Application Ref:	3/2025/0793			 Ribble Valley Borough Council www.ribblevalley.gov.uk
Date Inspected:	23/10/2025	Site Notice:	N/A	
Officer:	EP			
DELEGATED ITEM FILE REPORT:				
				APPROVAL

Development Description:	Proposed demolition of existing rear conservatory and construction of single-storey rear extension and new front porch. Addition of new render and composite boarding to external elevations and proposed new roof to existing garage.
Site Address/Location:	11 Whittam Crescent, Whalley, BB7 9SD.

SHEET:
PROPOSED ELEVATIONS

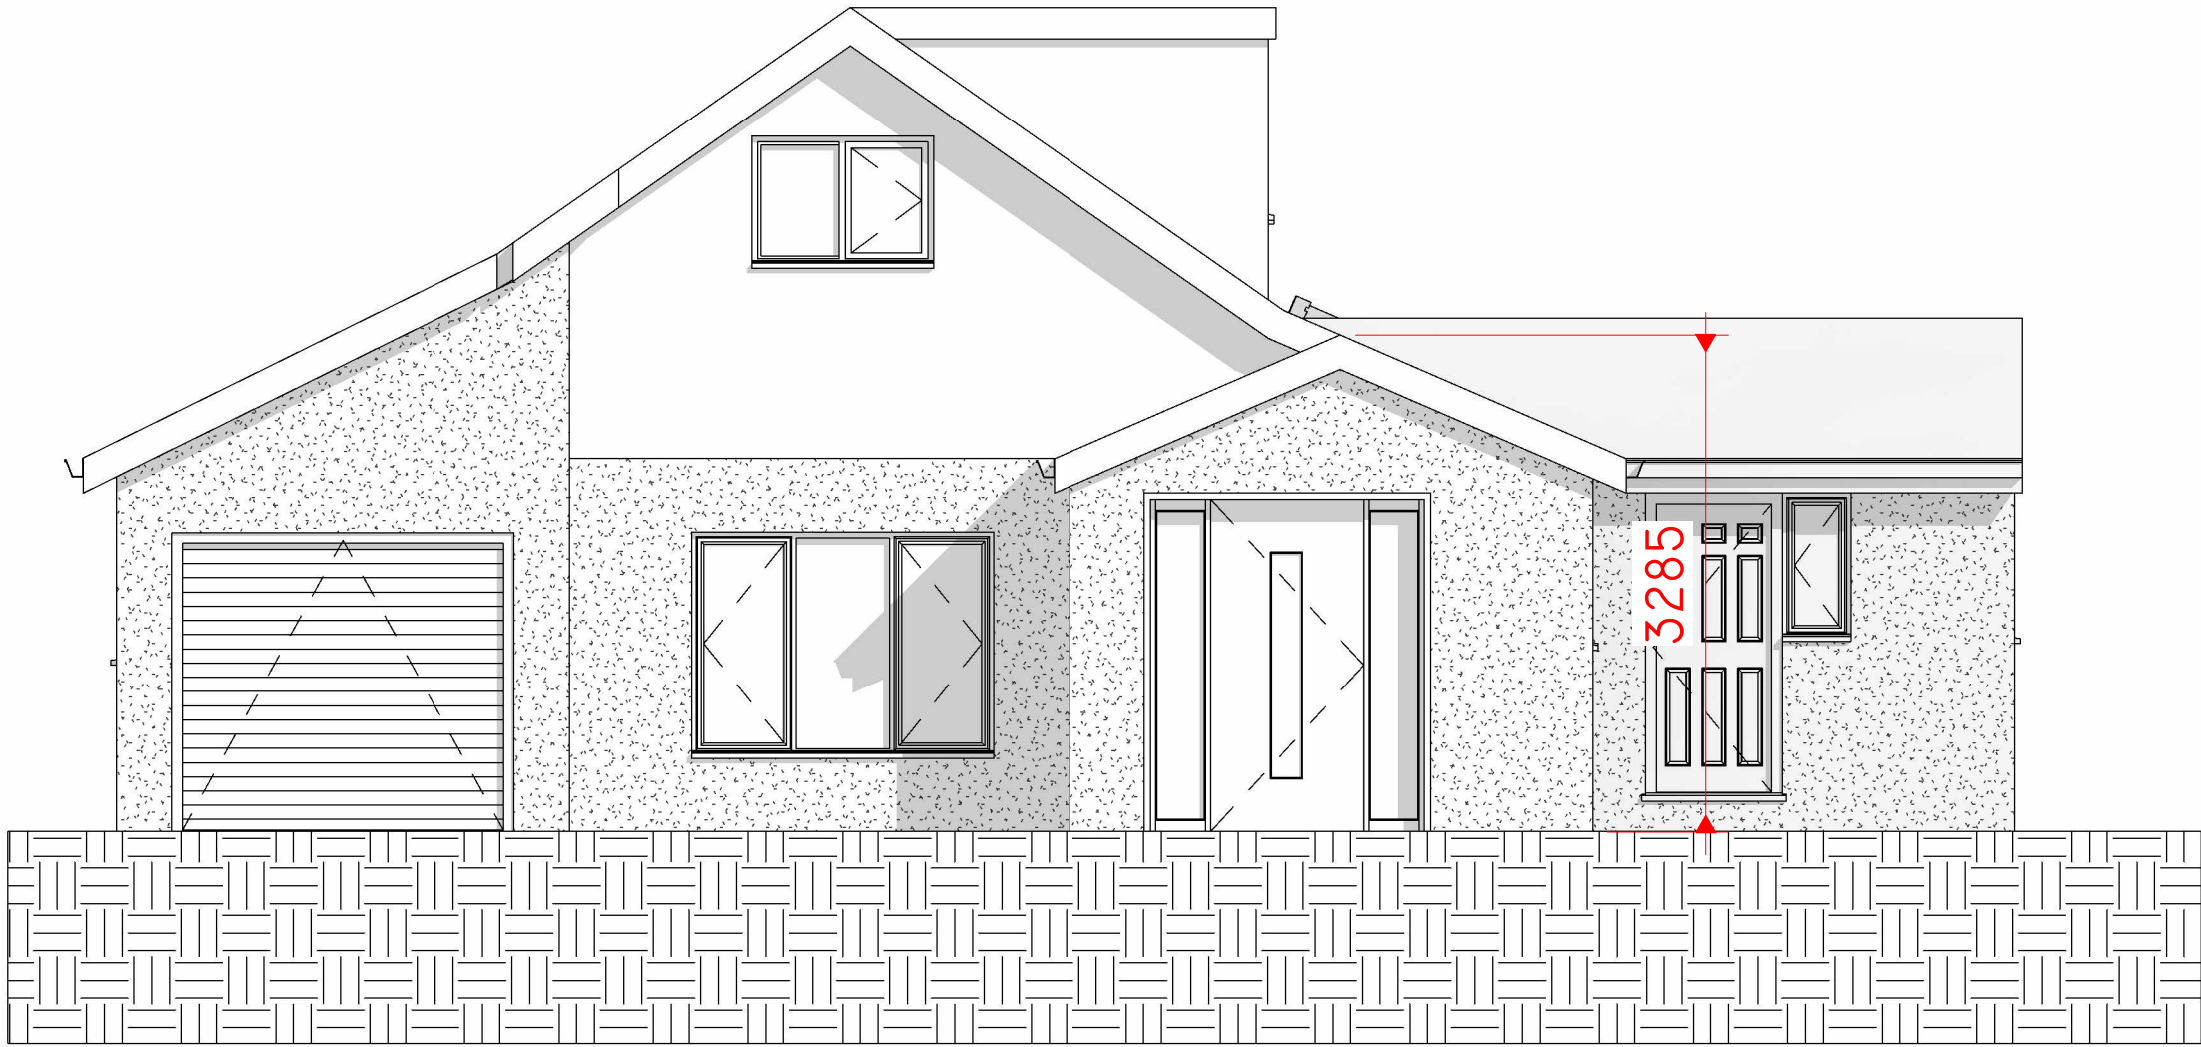
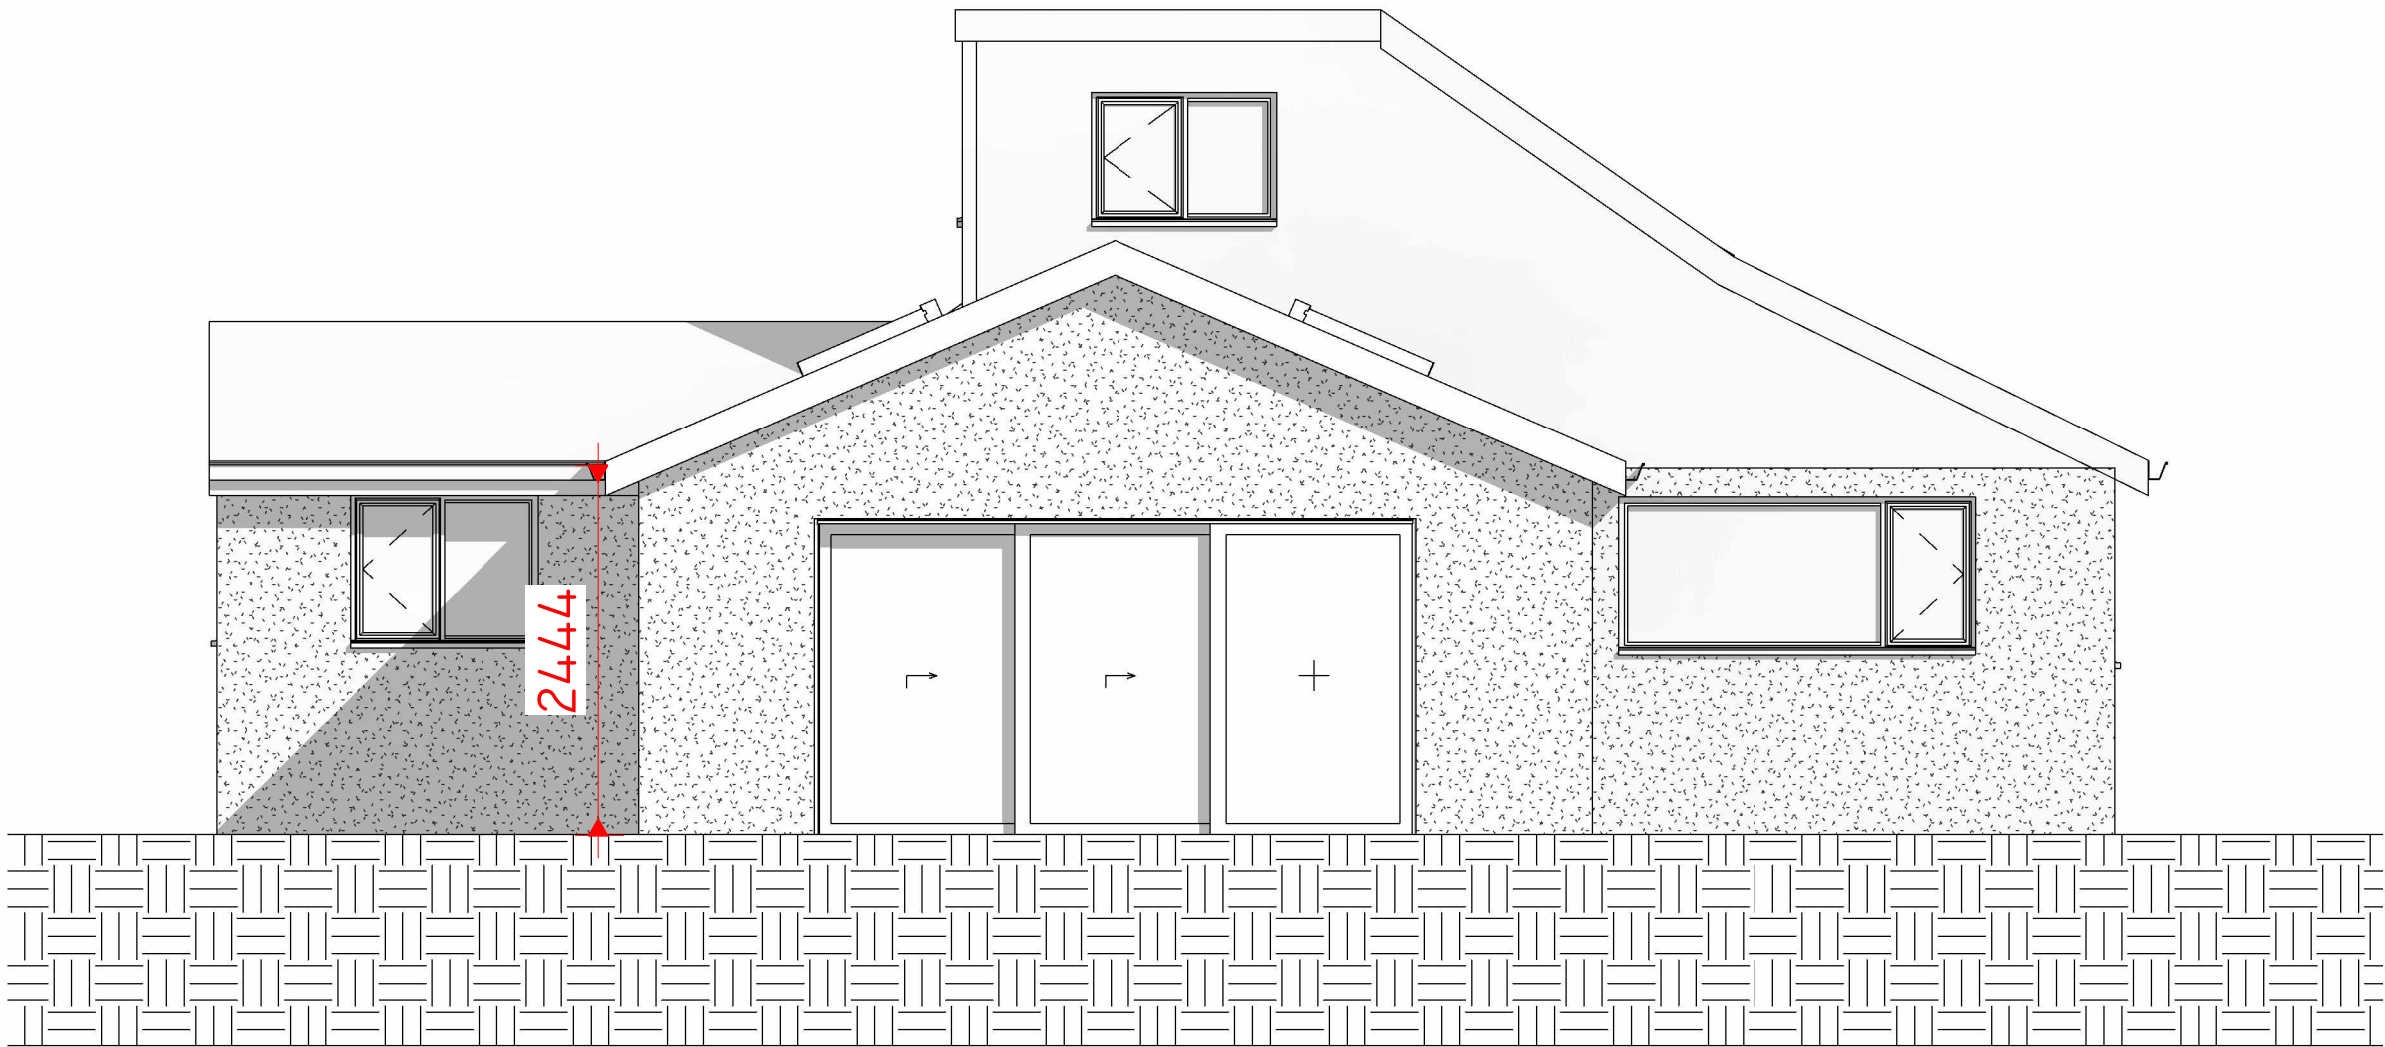
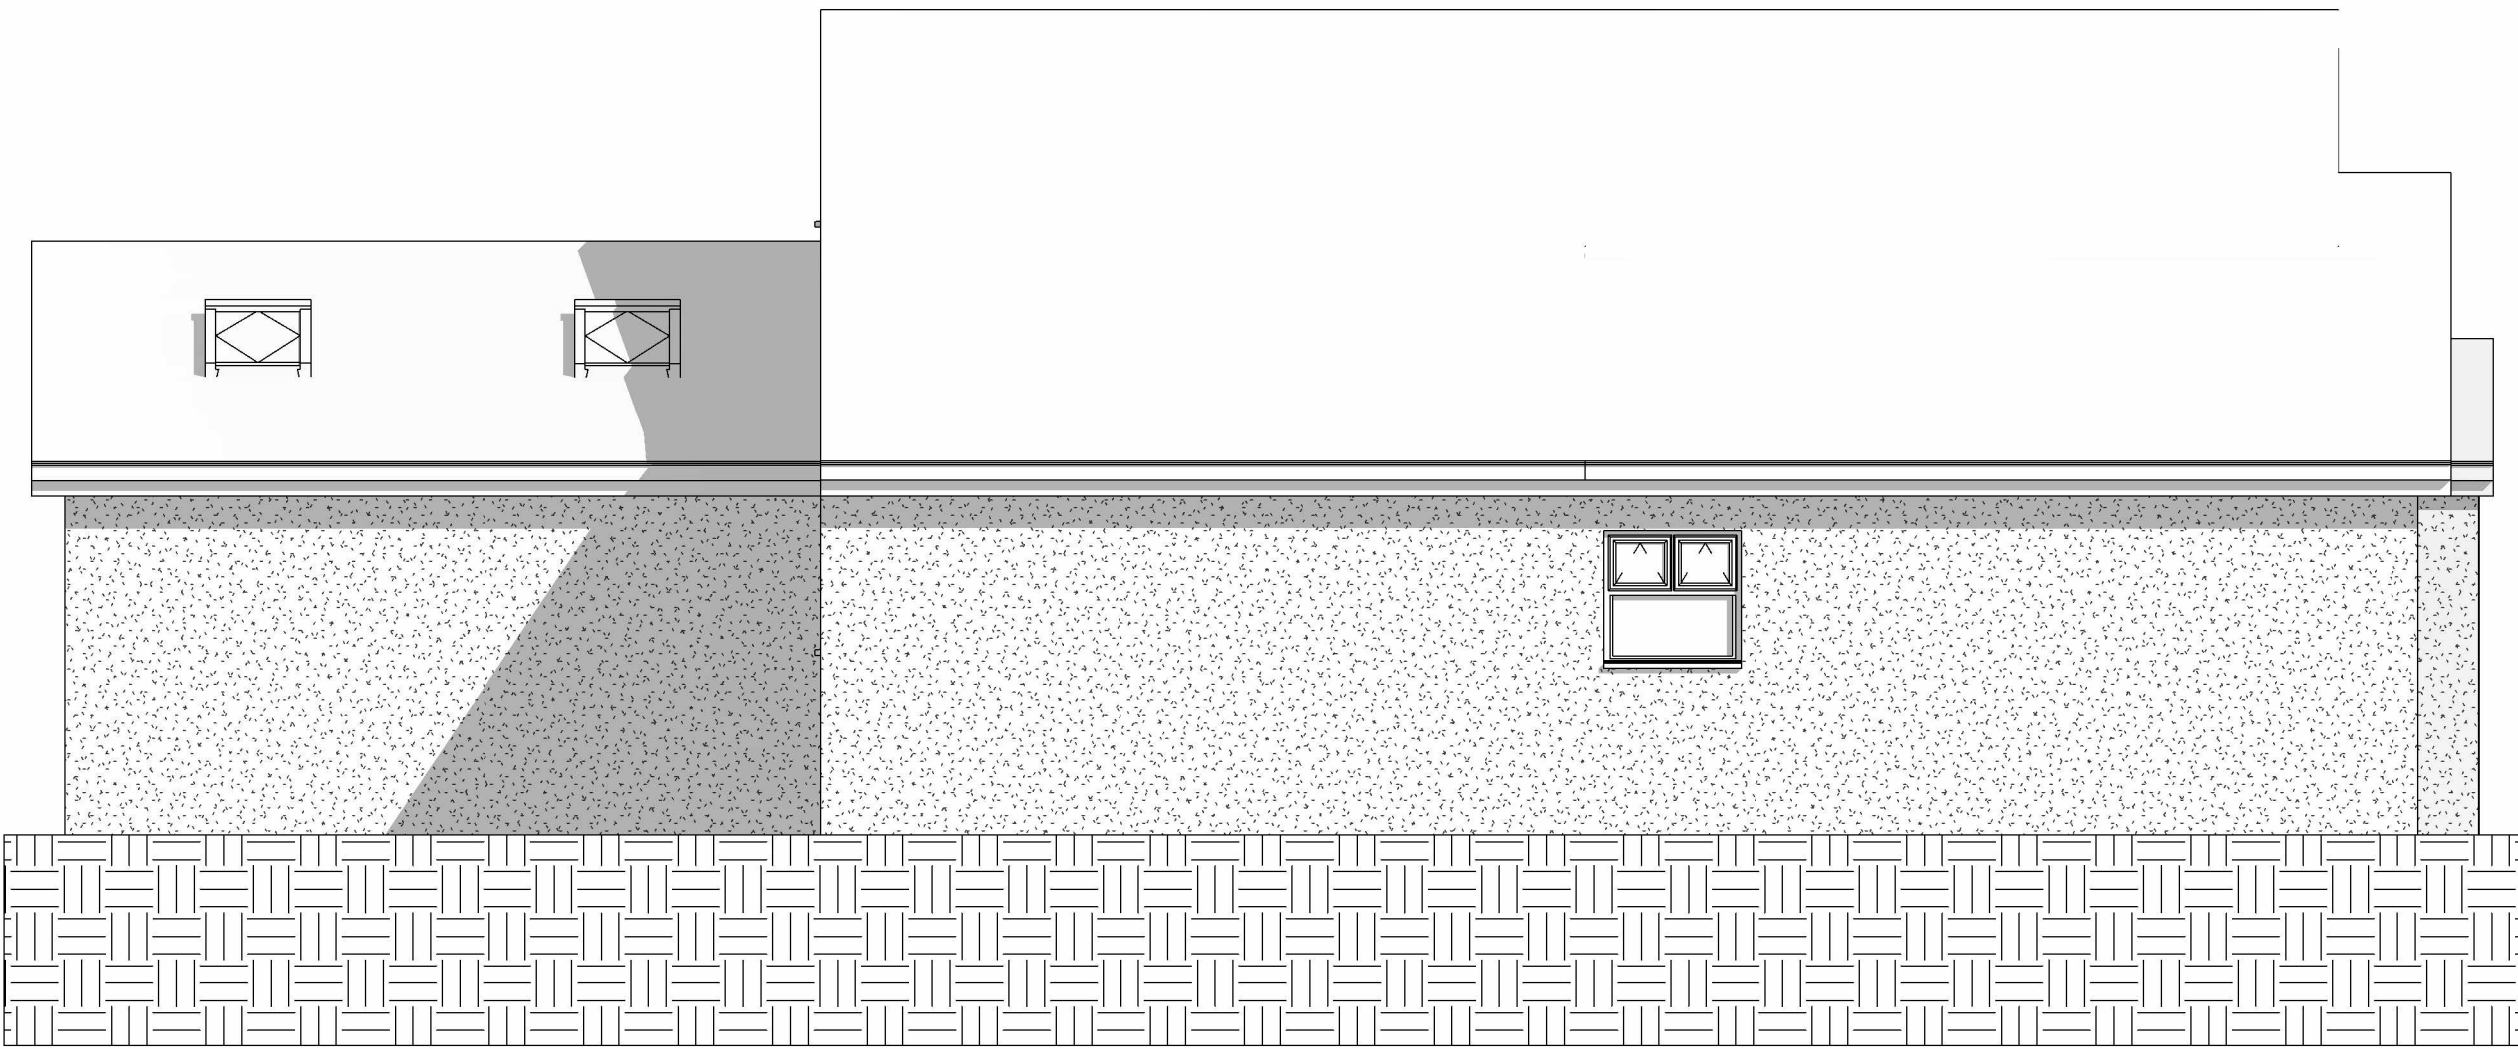
The proposed lean-to roof to the existing flat roof integral garage would also comprise a relatively minor addition to the application property and therefore would not result in any measurable adverse impact upon no.9 Whittam Crescent. The proposed rear extension would also comprise a rearward projection of 5m and would be adequately distanced from both nos. 9 and 13 Whittam Crescent so as to mitigate any resultant impact.

The proposed porch is of a modest overall footprint with an eaves and ridge height that is relative to that of the main dwelling. It would not result in a dominant addition to the property. The proposed incorporation of

a lean-to roof to the existing flat roof integral garage is also considered acceptable in this particular instance, given numerous other properties within the immediate vicinity of the proposal site benefit from a similar addition, namely nos. 13 and 15 Whittam Crescent.

The incorporation of render and boarding to the external elevations of the property would also remain in keeping with the external facing materials utilised within the existing street scene. Details of the proposed light grey boarding have been submitted and are considered appropriate with similar variation being found in the vicinity.
